Our ref: SSI-10049

19/11/2021

Kamay Ferry Wharves Project (SSI-10049)
Request for additional information

Figure 10-9: Construction impacts at La Perouse

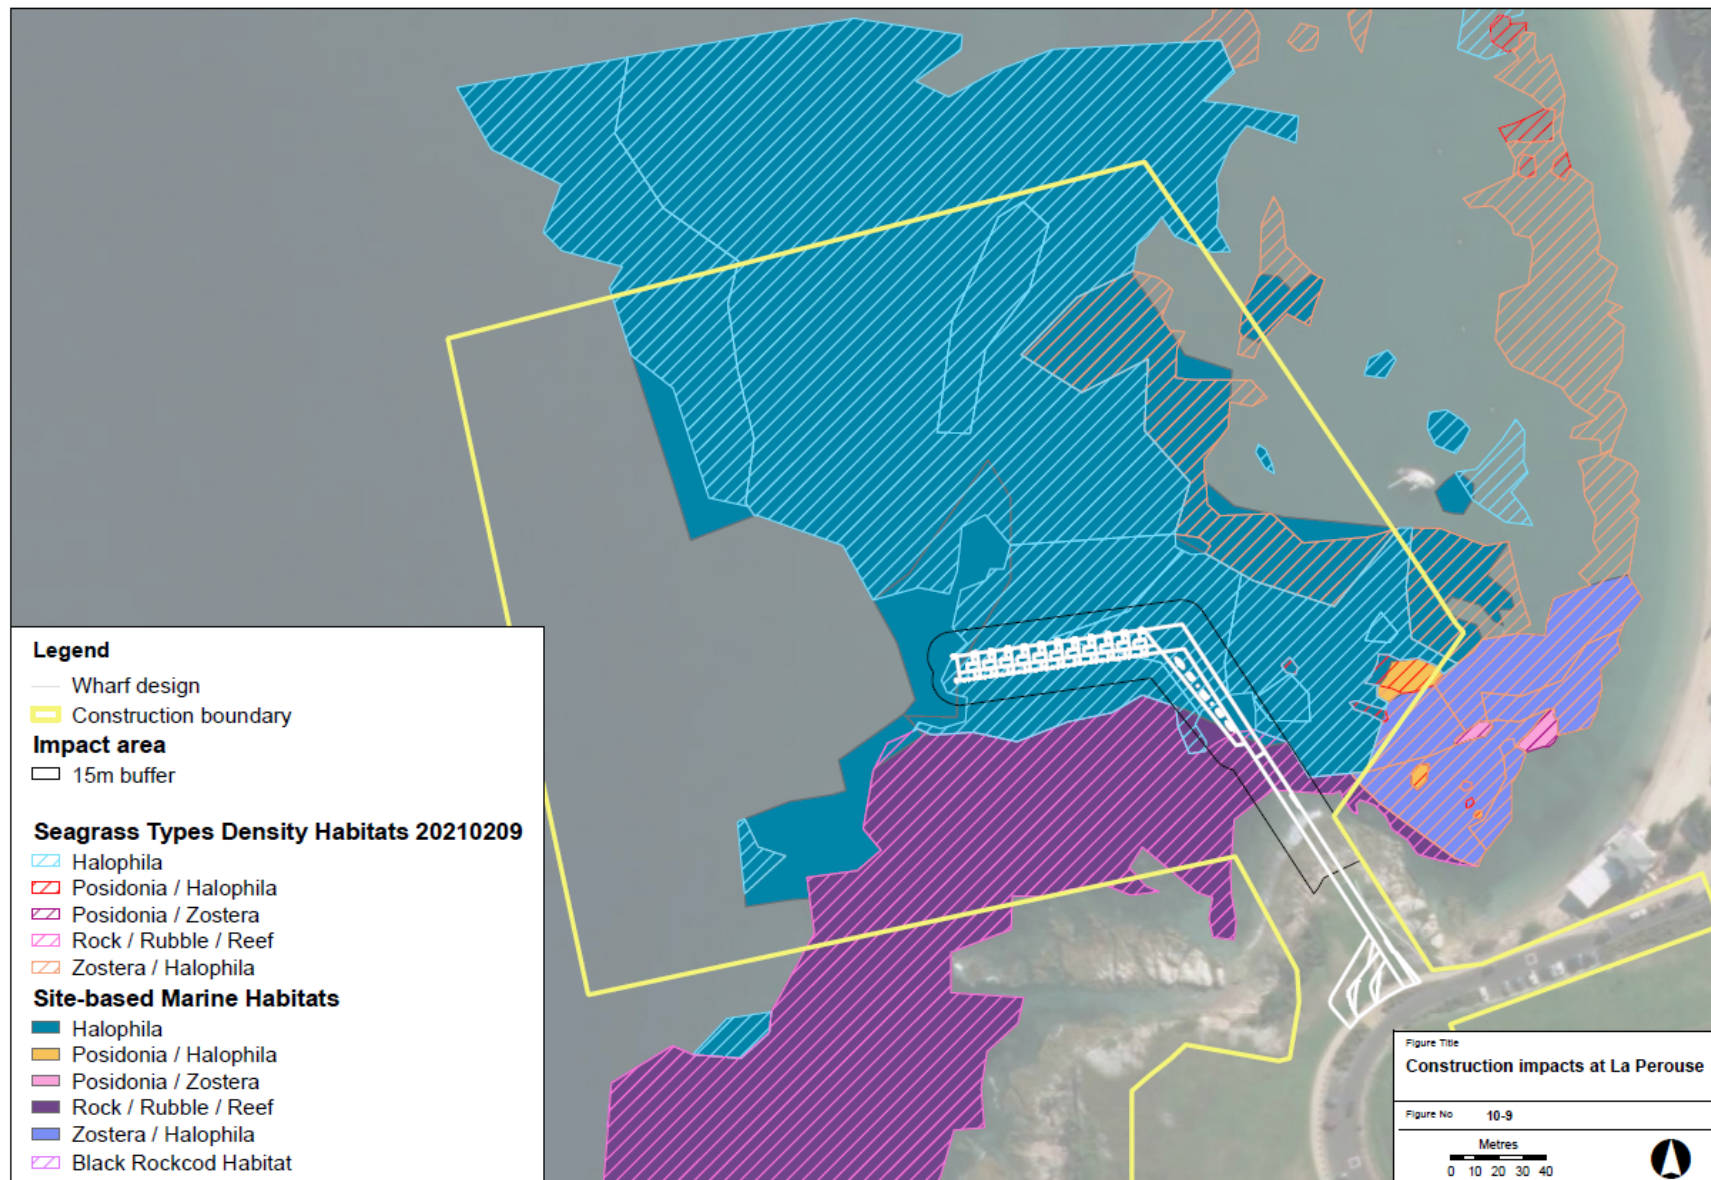
- Identify all potential direct and indirect impacts associated with construction and operation of the project, including *Posidonia australis*, White's Seahorse and Black Rockcod. The MBOS should be revised to ensure compliance with *NSW Biodiversity Offsets Policy for Major Projects Fact sheet: Aquatic biodiversity*.
- Demonstrate how the risk of failure of proposed *Posidonia australis* transplantation will be reduced or managed, noting that use of the monetary bond to achieve this would form only part of the approach.
- Identify potential impacts of ferry type and manoeuvring on seagrass beds including scouring effects.
- Clarify why a maximum lifespan of 5 years is proposed for the MBOS.
- Identify the 'before' benchmark for KPIs measuring the success of MBOS actions.
